STATE OF NORTH CAROLINA
DEPARTMENT OF TRANSPORTATION

Addendum No. 1

RE: Contract # C204224

1 Section of US-13/US17, 4 Sections of NC-32, 1 Section Of US-64 Alt, 1 Section Of US-64 And 1 Section Of NC-45/NC-99

TYPICAL SECTION NO. 3

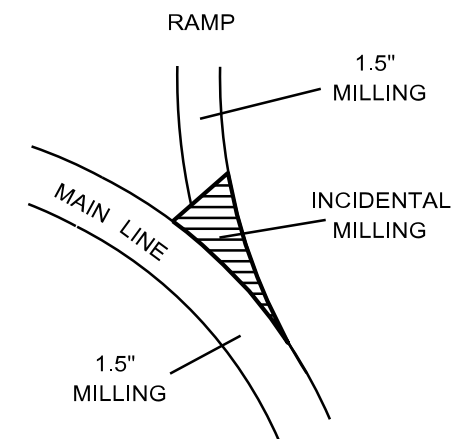
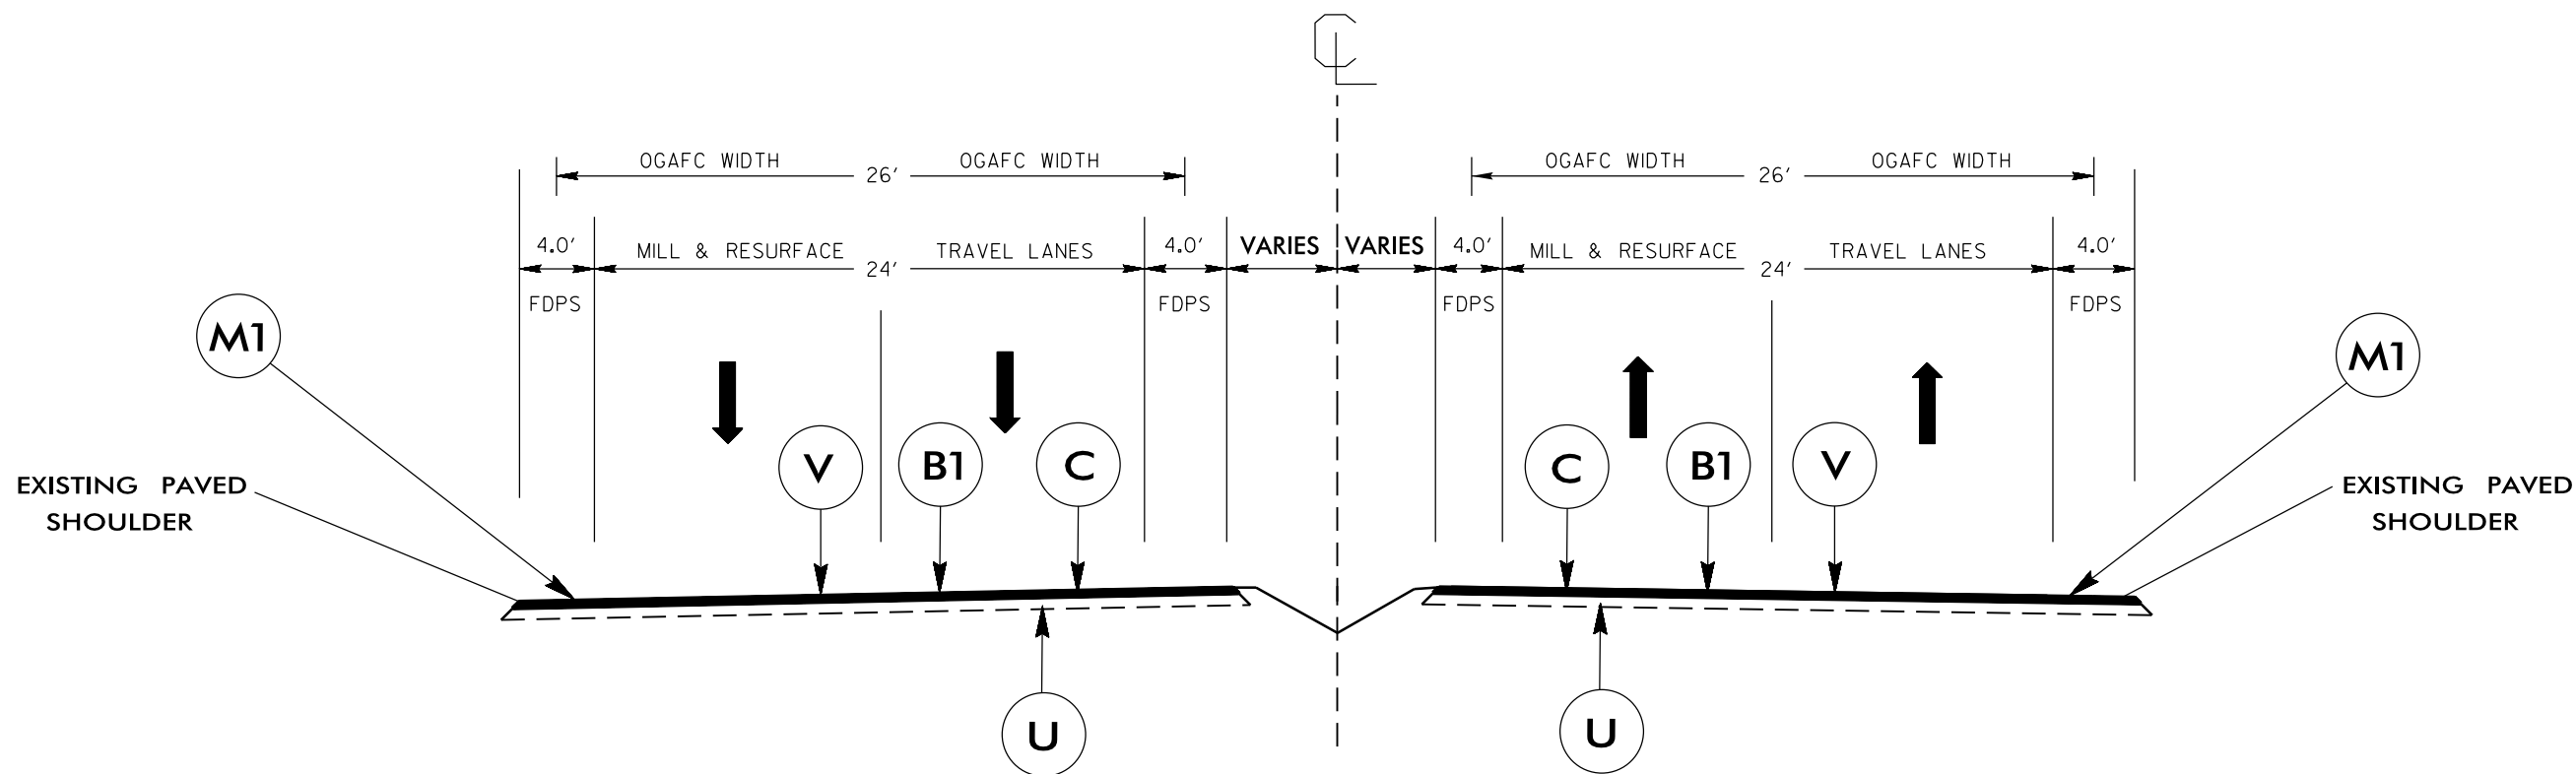
Sheet No.	Revisions
7	Added a new note and added Detail A
9	Revised to add columns for Remove and Replace Existing Guardrail and Temporary Crash Cushions
